Application Reference: 2025/0779

Site Address: 1 Melford Close, Staincross, Barnsley, S75 6EF

This application seeks full planning permission to raise the roof to create a loft conversion and install a rear dormer and velux windows to the front elevation.

Drawing Title **PROPOSED ELEVATIONS**

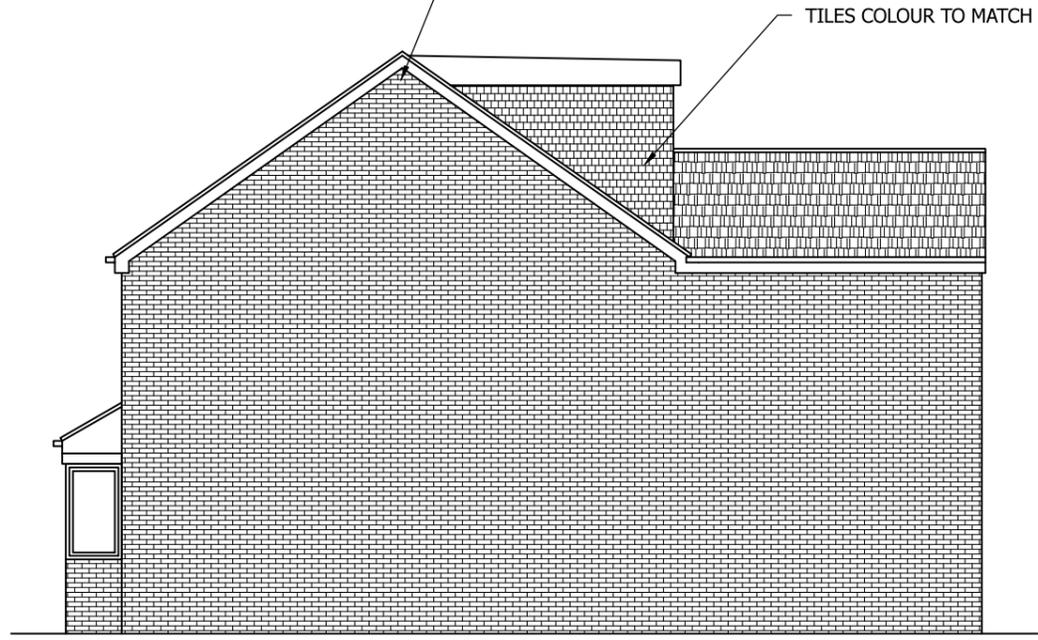
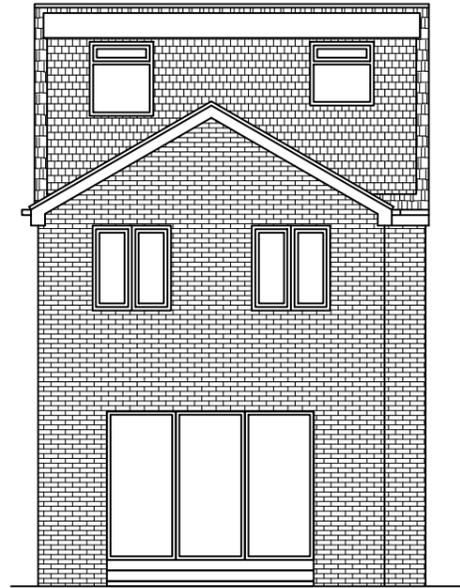
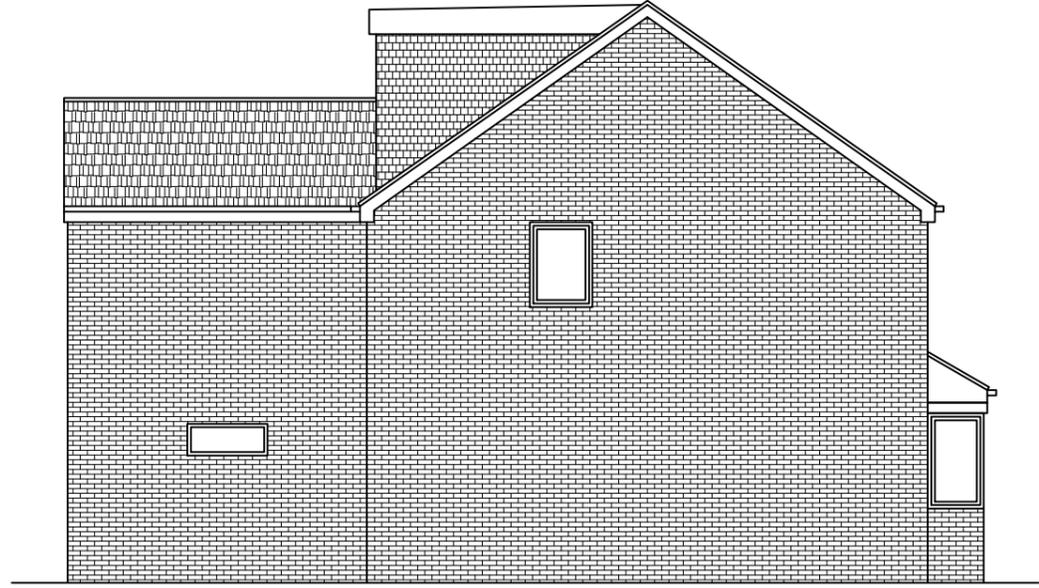
The proposal is to raise the height of the roof by just over half a meter (0.6m). The host property is a two storey detached dwelling within a street scene of properties with a staggered height. Due to the topography of the site properties along Melford Close are stepped down from the height of the properties along New Road. Due to the site levels the proposal is not expected to appear out of character within this setting and will barely rise above the neighbouring properties.

SPD: House Extensions sets out the design principles for dormer roof extensions. So as not to dominate existing roof lines and retain the original form of the host property, dormer windows should be set within the roof plane following the guidelines set out within the policy. The original proposal encompassed a large overly dominant rear dormer which was deemed unacceptable and contrary to policy. The scheme has been amended to reflect the principles within SPD: House Extensions, by reducing the size of the proposal. The amended proposal is now acceptable in terms of the visual impact.
